Date: 31st January 2019  
Our ref: CPD: 10552019  
Your ref: 6/2018/3292/MAJ  
Direct No: 01707 355225  
E-mail: [gerry.brophy@herts.pnn.police](mailto:gerry.brophy@herts.pnn.police).

**Re: 41 Broadwater Road**

Thank you for sight of this application on which I comment from a crime prevention perspective.

SITE PLAN - BOUNDARY TREATMENTS & FENCING

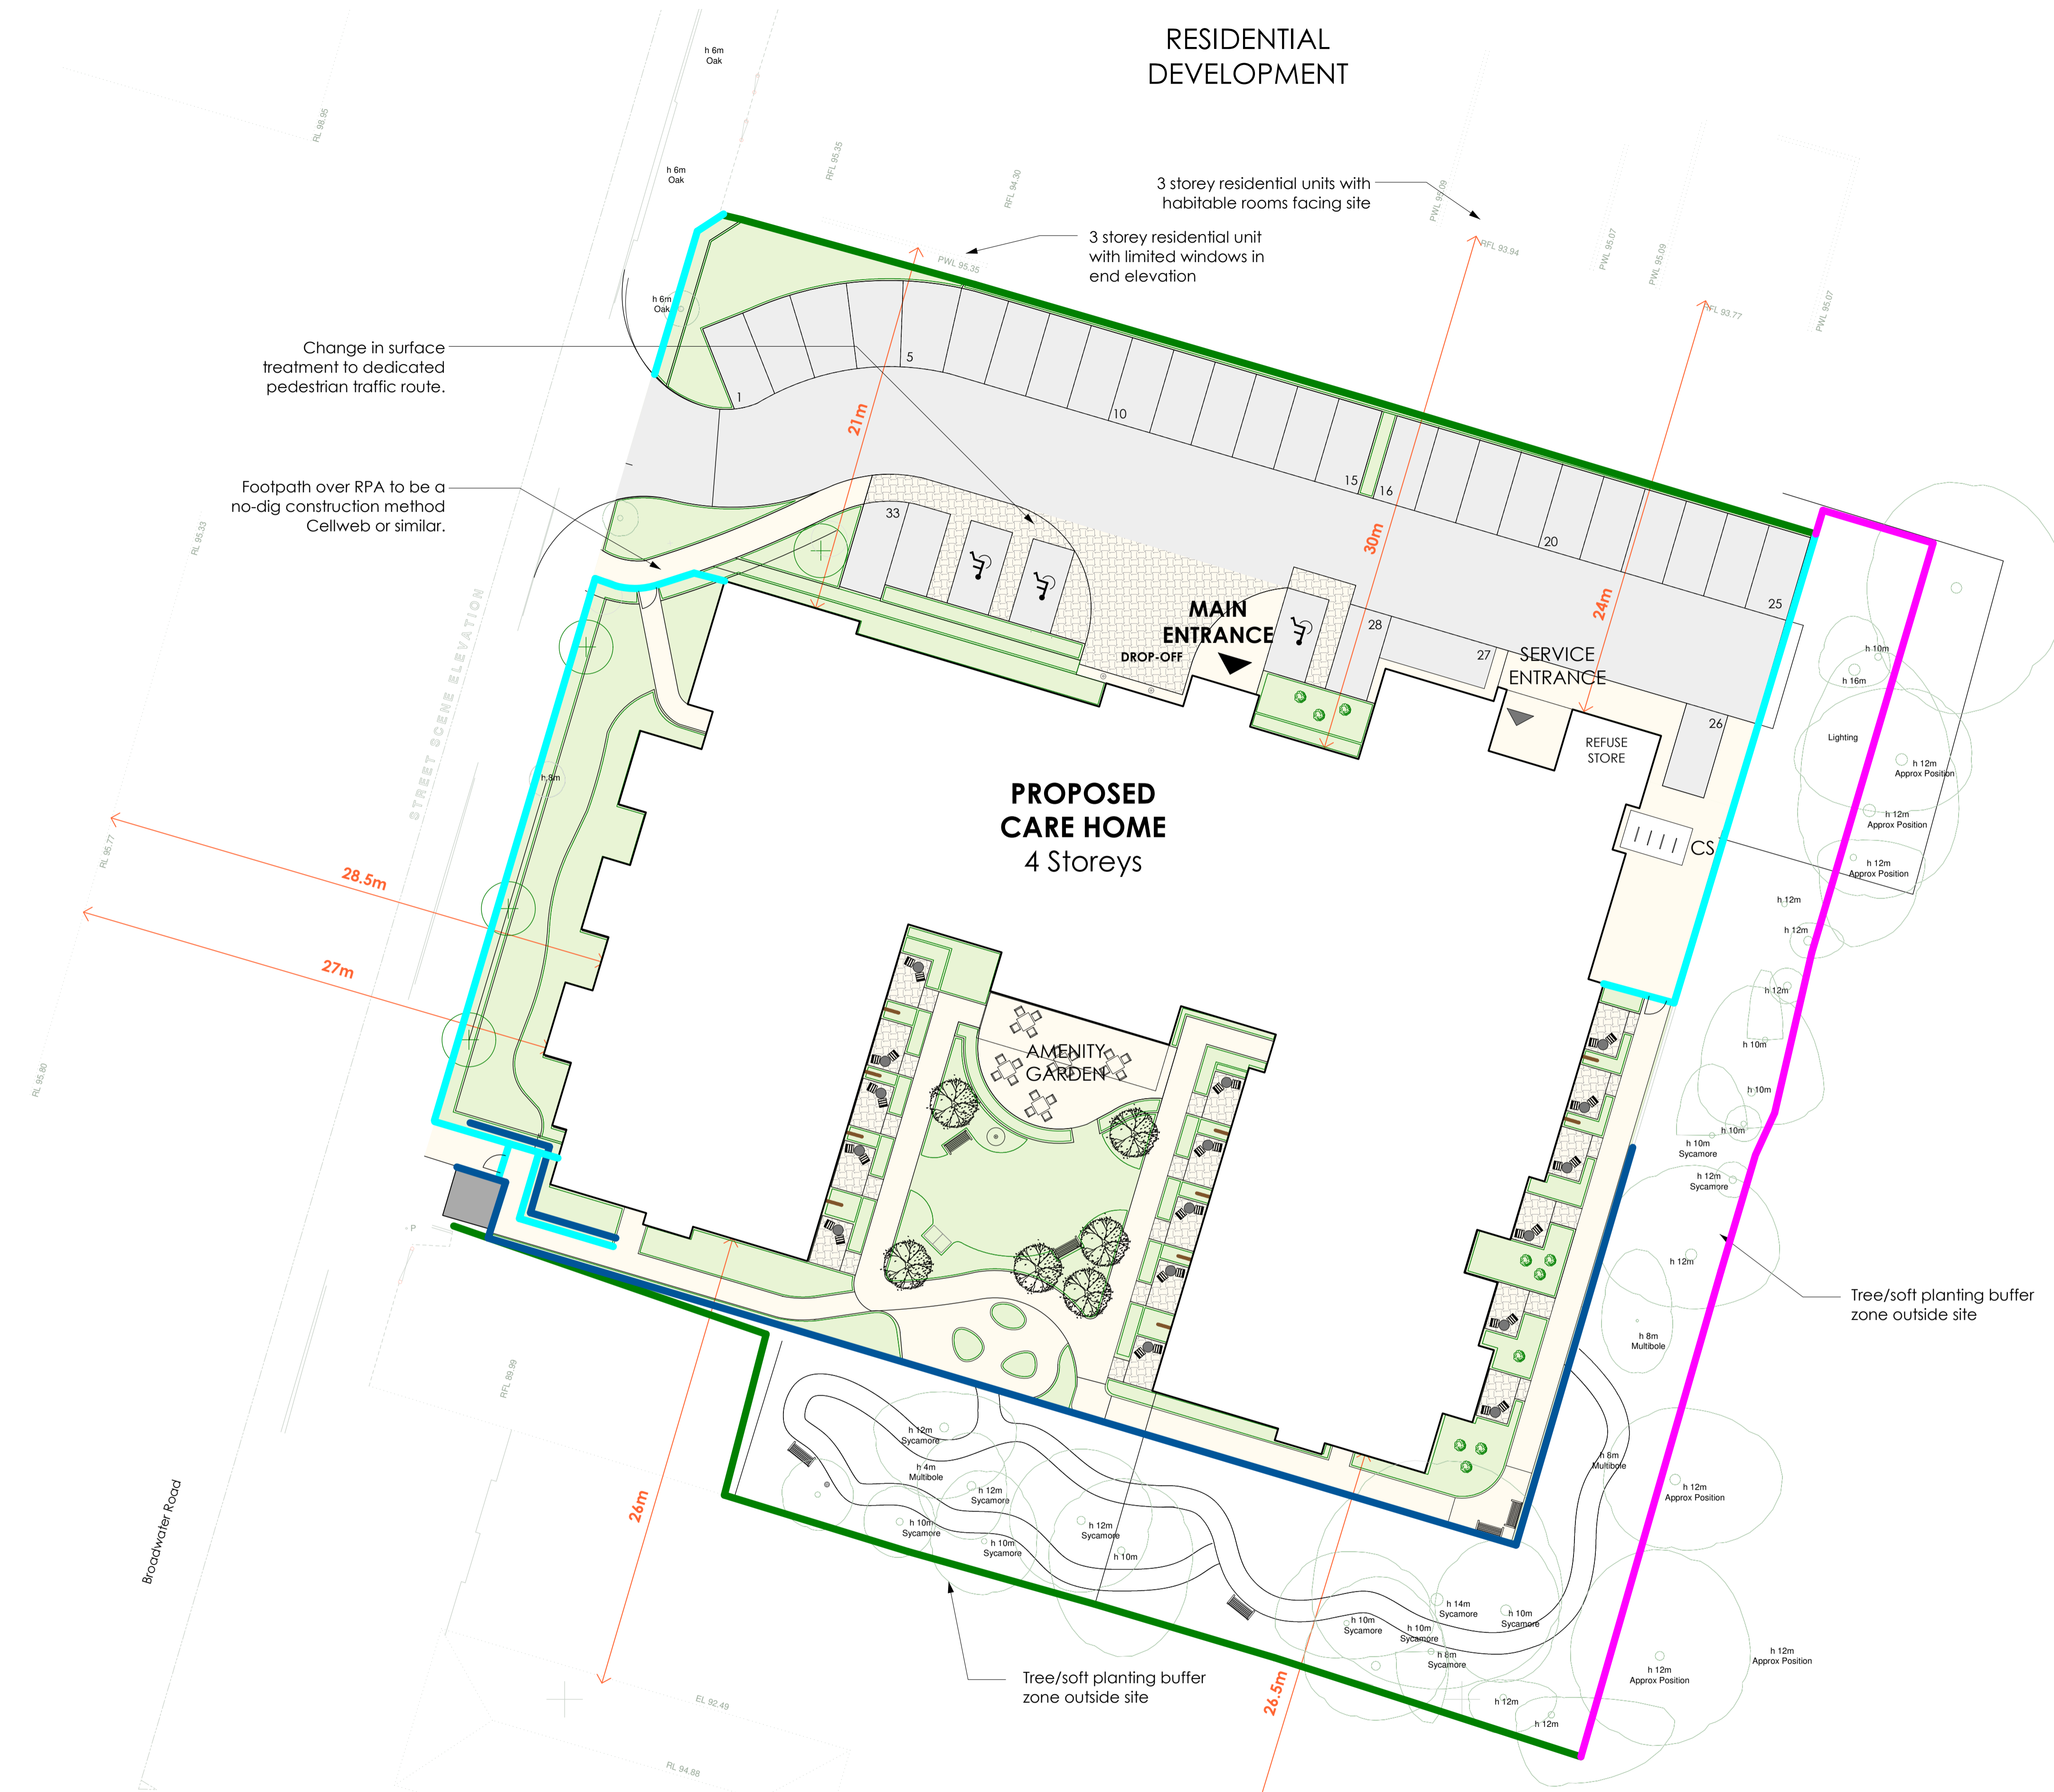
The perimeter fence must ensure that the general public are kept out, but must also be capable of keeping residents within the safety of the gardens. This is especially important due to the very busy road outside the development.

GROUND FLOOR PLAN - AS PROPOSED
 Scale 1:100 @ A1

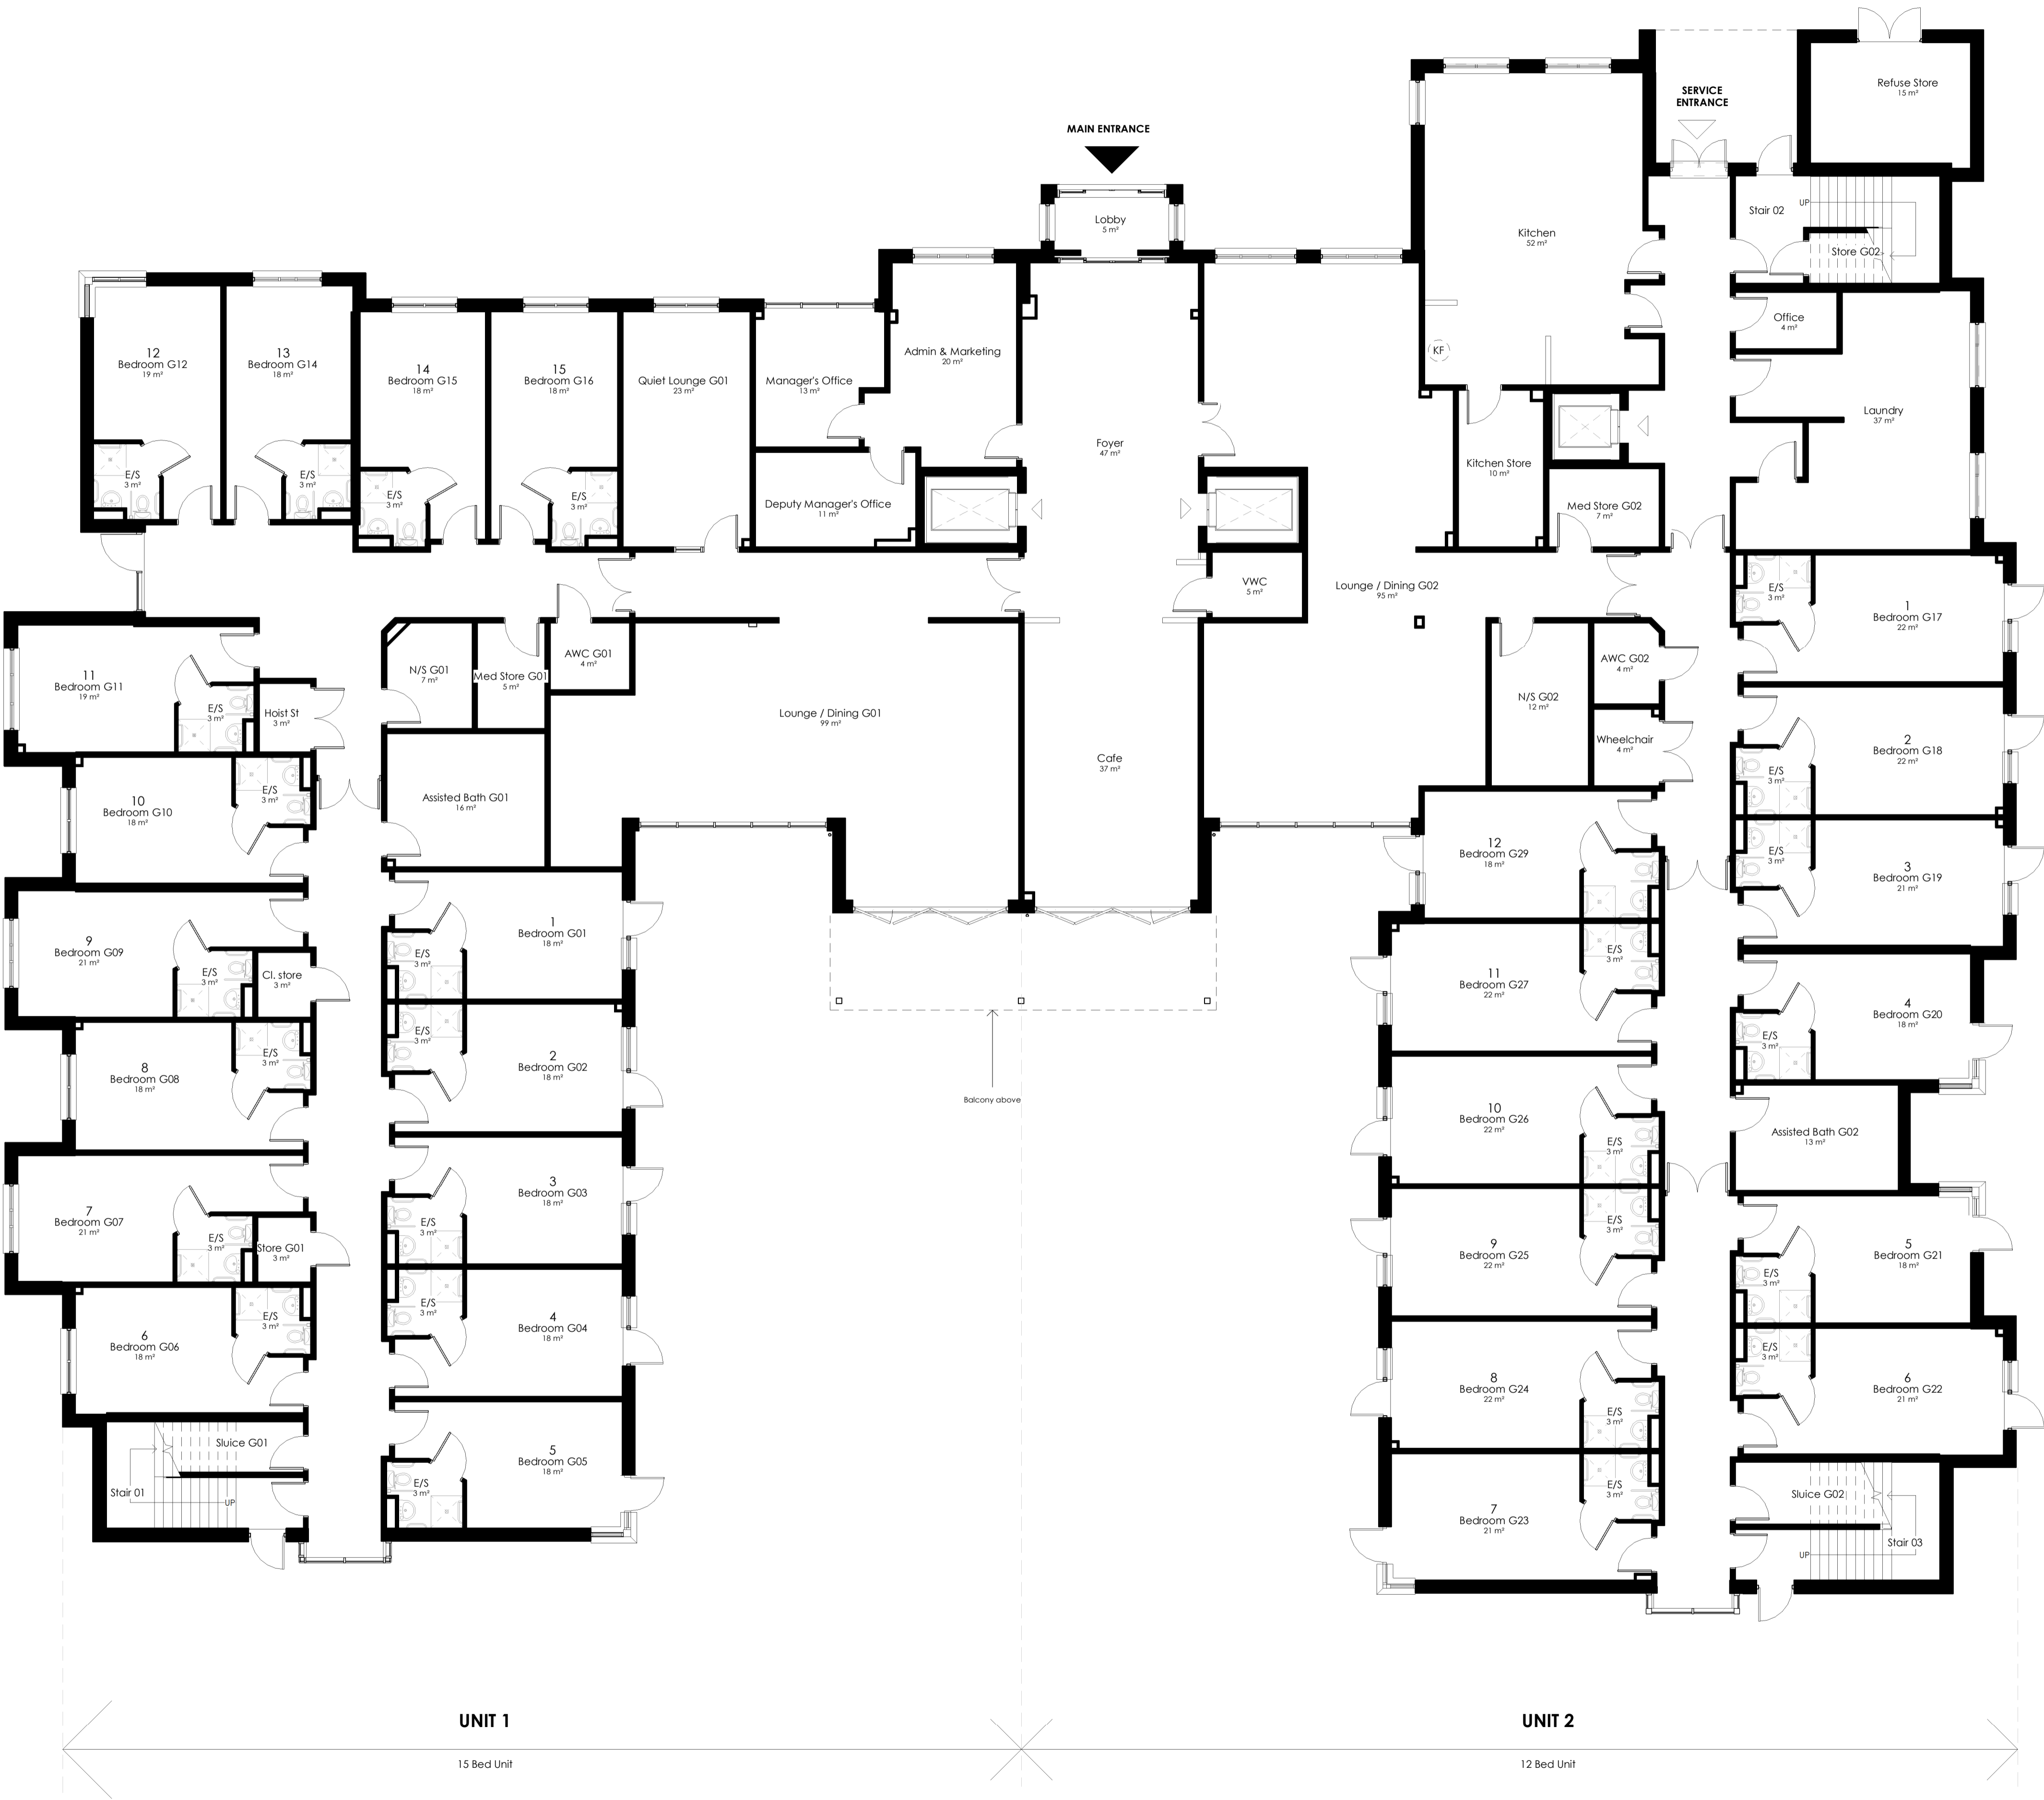
The main entrance should have some control to prevent potentially confused occupants walking out. This could be by staff during the day and some form of electronic control after hours.

Having spoken with the architect involved, I now understand that there will be 24 hour staff on scene to control the door.
